**Application by National Grid Electricity Transmission Plc for an Order granting Development Consent for the National Grid Norwich to Tilbury Project**

**Planning Inspectorate Reference Number: EN020027**

**Deadline 2: Comments on any further information or submissions made by the Applicant and received by deadline 1 submitted on behalf of National Highways Limited**

Site 48
Galleys Corner

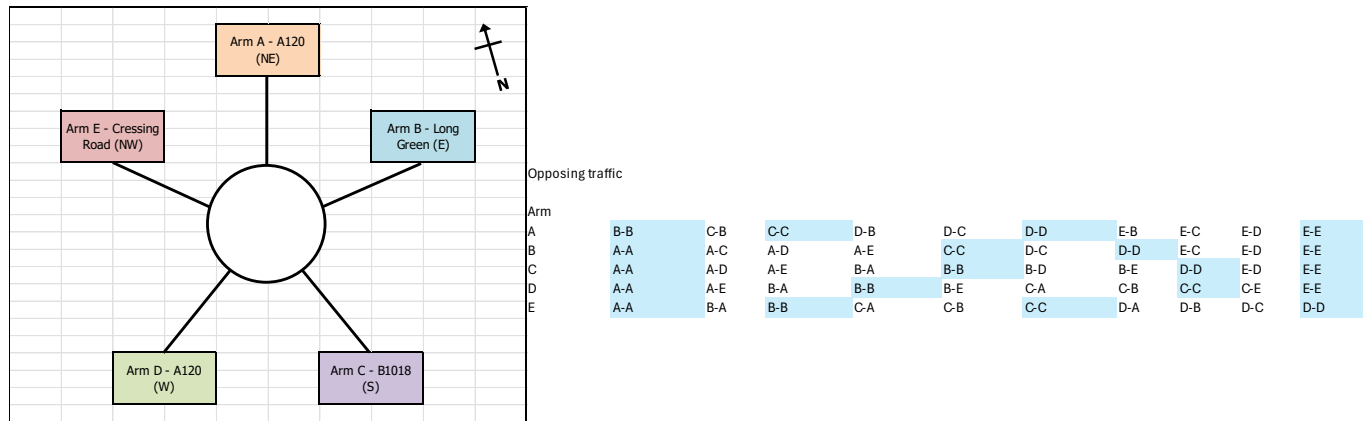
*i) Site 48: A120/Long Green/B11018/Cressing Road junction (Galley's Corner)*

This junction was modelled using ARCADY. AECOM, however, have advised NH that a microsimulation model (using software such as Vissim) would be more suitable to assess the impact at this junction. This is due to the interactions between the Galley's Corner roundabout, the A120/A131 Marks Farm roundabout to the north, and the B1018/Millennium Way roundabout to the south.

NH notes that there is a history of serious congestion in this area, with queues frequently backing between the junctions. This occurs over an extended peak period, with congestion on the A120 eastbound starting early in the afternoon. There is also an early AM peak due to the 'early commute' towards the M11, whilst the presence of the nearby shopping village also results in congestion on a Saturday.

Additionally, whilst the development traffic flows are not agreed at this stage, it is noted from the traffic flow matrices within the Galley's Corner ARCADY model that there approximately 178 vehicles assigned to the Marks Farm roundabout in the AM Peak and approximately 151 in the PM peak. Therefore, NH strongly advises

that a microsimulation model, that includes the A120/A131 Marks Farm and B1018/Millennium Way roundabouts, should be used to assess the impact at this junction and provide assurance that the SRN will not be adversely affected by the development in this area.
